CITY OF ALBUQUERQUE

May 27, 2020

**Re: Lot 22 Meridian Business Park
541 Silver Creek Rd NW
Traffic Circulation Layout
Engineer Stamp XX-XX-XX(K10-D023I)**

SHEET # SP-1
			JOB # 2020033

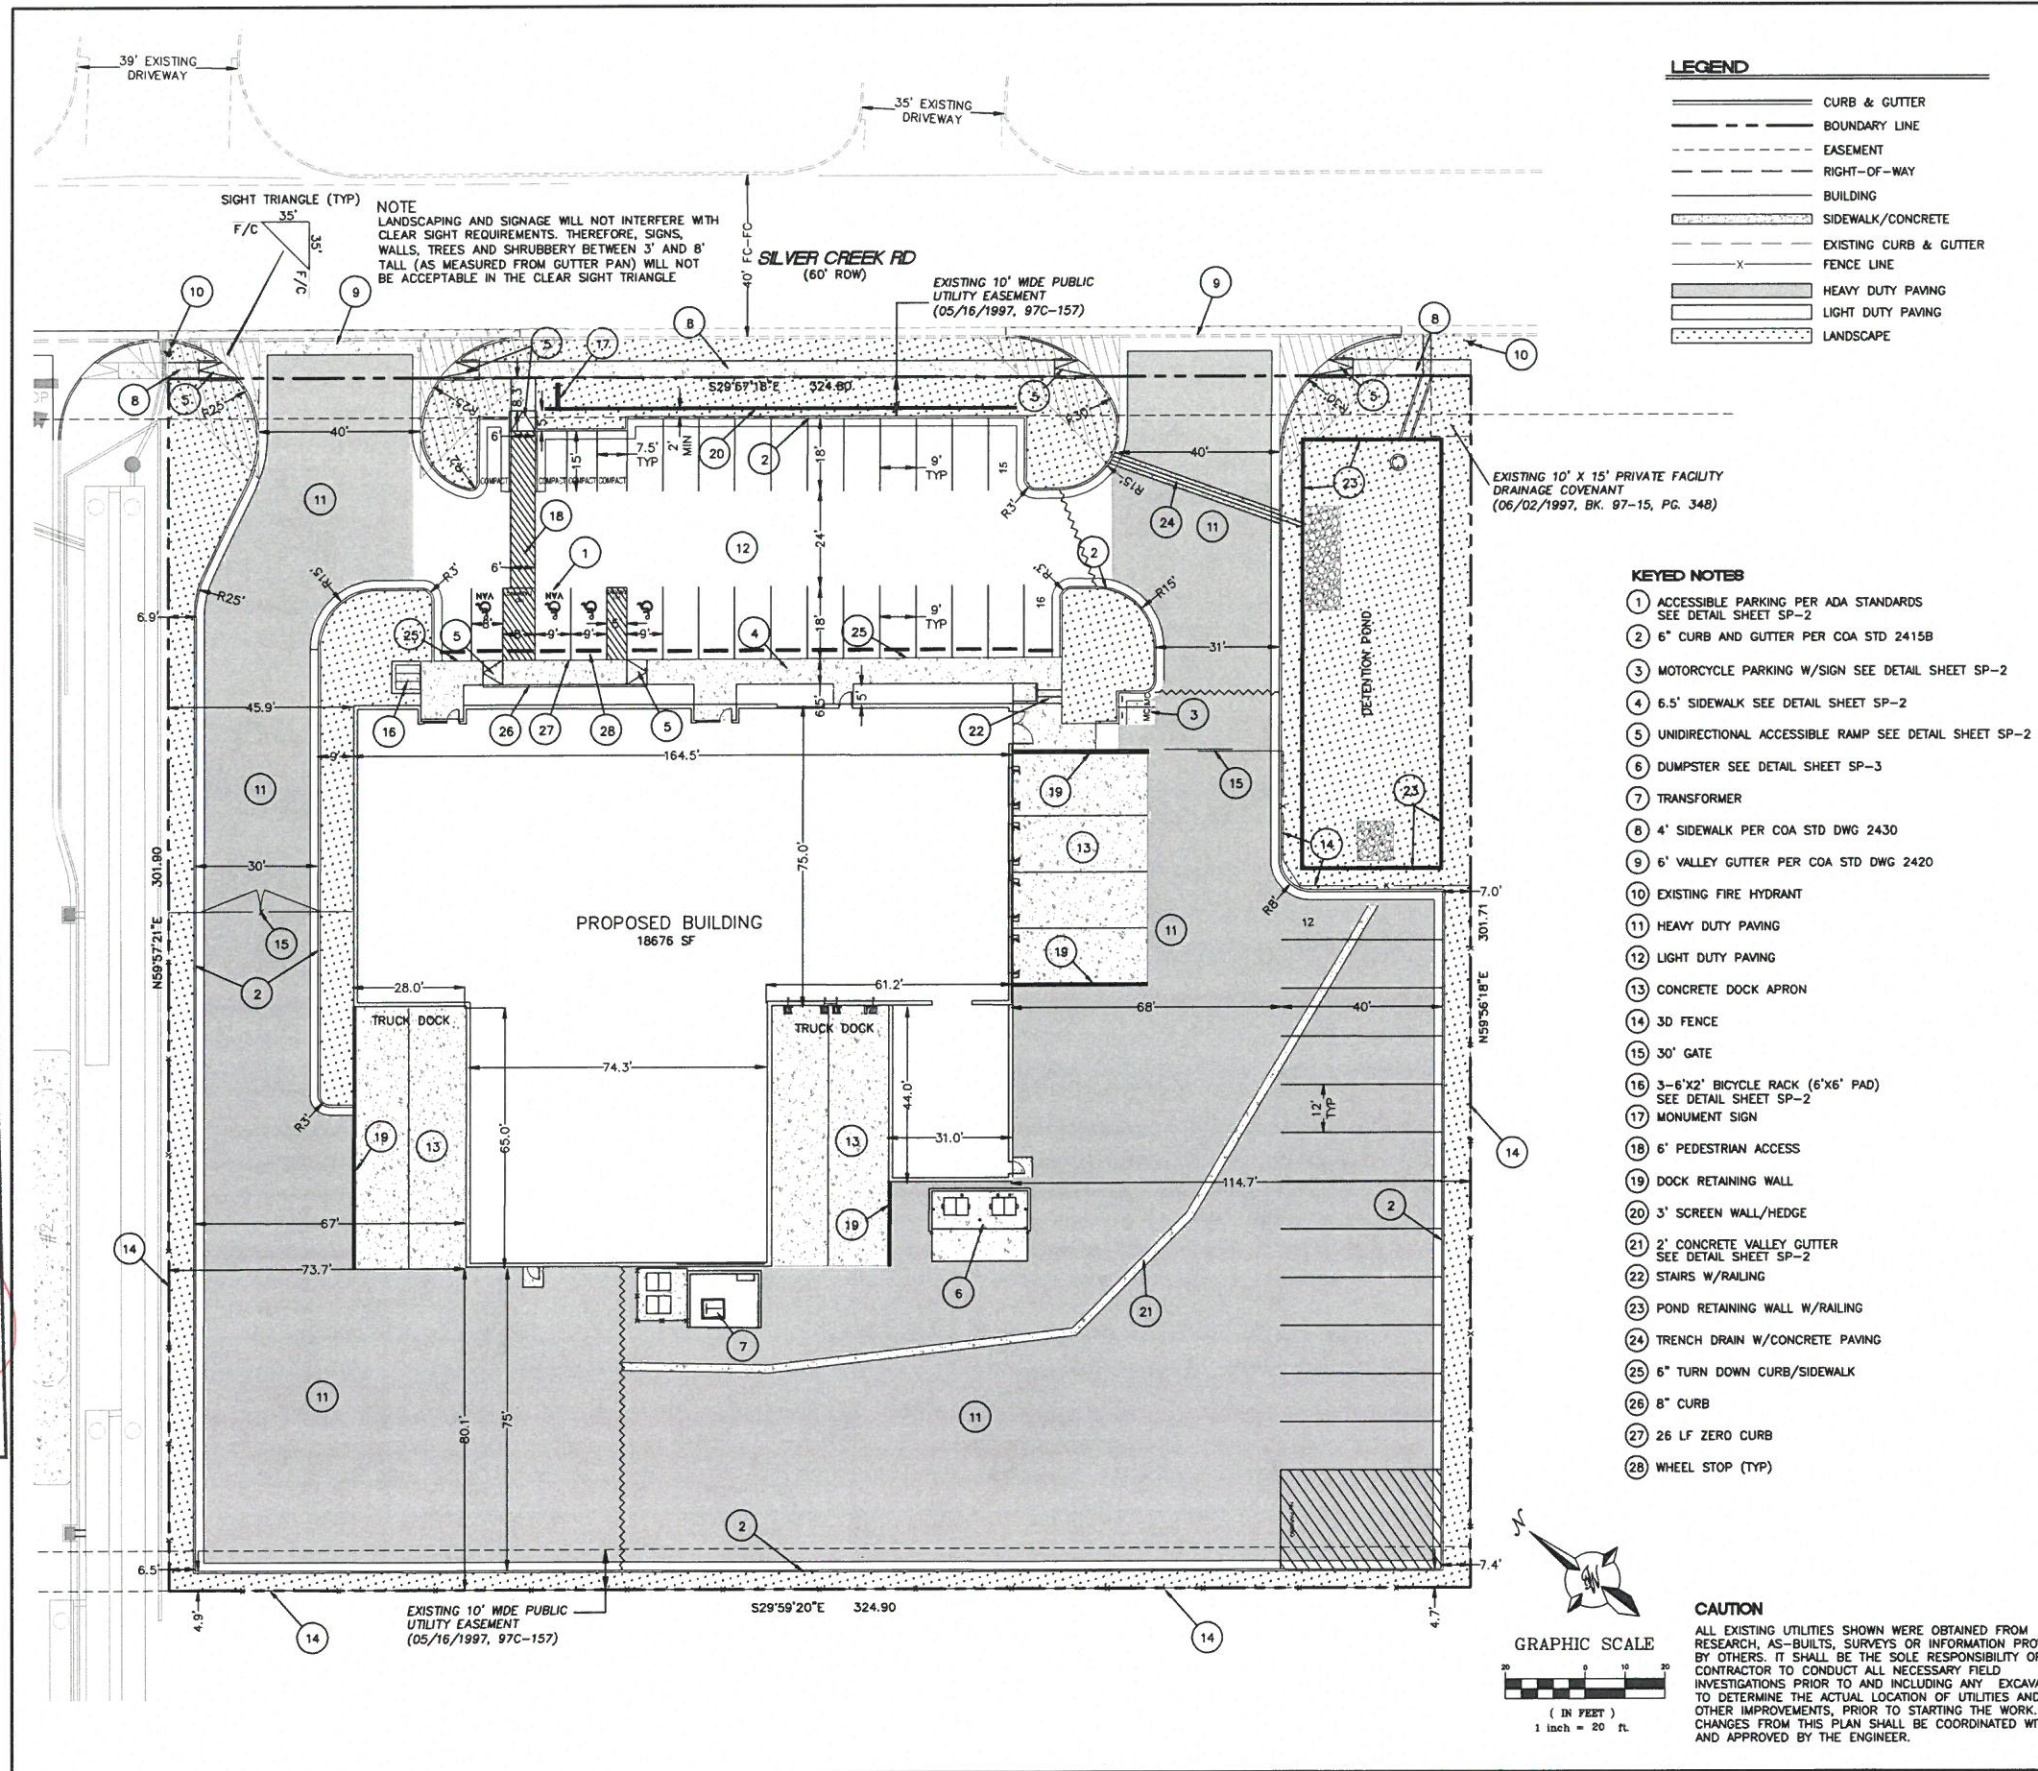
1. Please coordinate all calculations for parking spaces, including bicycle and motor cycle parking with Zoning and list the number required.
2. The traffic circulation layout plans must be stamped, signed, and dated by an engineer licensed in the state of New Mexico.
3. Identify the right of way width, medians, curb cuts, and street widths on Silver Creek Road.
4. Maximum access width for arterial, collector, and local streets (**Silver Creek Rd**) are as follows:

6. Label the compact parking spaces by placing the words "**COMPACT**" on the pavement of **each space**.
7. Please reference detail sheet SP-2 for Keyed notes 1, 3,4, 5, 6,& 16.

8. All proposed ramps onsite must have a detail provided.
9. Label all proposed sidewalk with public roadway with keyed note 8.
10. All bicycle racks shall be designed according to the following guidelines (**if applicable**):

14. Radius for delivery trucks, fire trucks, etc. is 25 ft. or larger. Please provide turning templates for delivery vehicle from public roadway into and out of site.

15. Per the IDO, a 6 ft. wide ADA accessible pedestrian pathway is required from the public sidewalk to the building entrances. Please clearly show the 6 ft pathway and provide curbing adjacent to parking stall. All proposed ramps onsite must have a detail provided.

16. ADA accessible pedestrian pathway should not be placed behind parking space or adjacent to a vehicular way. Vehicle and pedestrian/wheel chair conflicts should be avoided as much as possible. The proposed 6ft pedestrian pathway appears to be in conflict with the proposed ramp.

17. Parking areas shall have barriers to prevent vehicles from extending over public sidewalk, public right-of-way, or abutting lots and proposed 6 ft pedestrian pathway in front of building entrance.

18. Provide a copy of refuse approval.
19. The proposed monument sign cannot encroached onto public right of way (this includes air space).
20. Please specify the City Standard Drawing Number when applicable.

22. Provide notes showing what work is included and on the work order and the private work on site.
23. Work within the public right of way requires a work order with DRC approved plans.
24. Please add a note on the plan stating "All improvements located in the Right of Way must be included on the work order."
25. According to AGIS, the property line doesn't appear where you have shown on the Site Plan. Please address this matter.
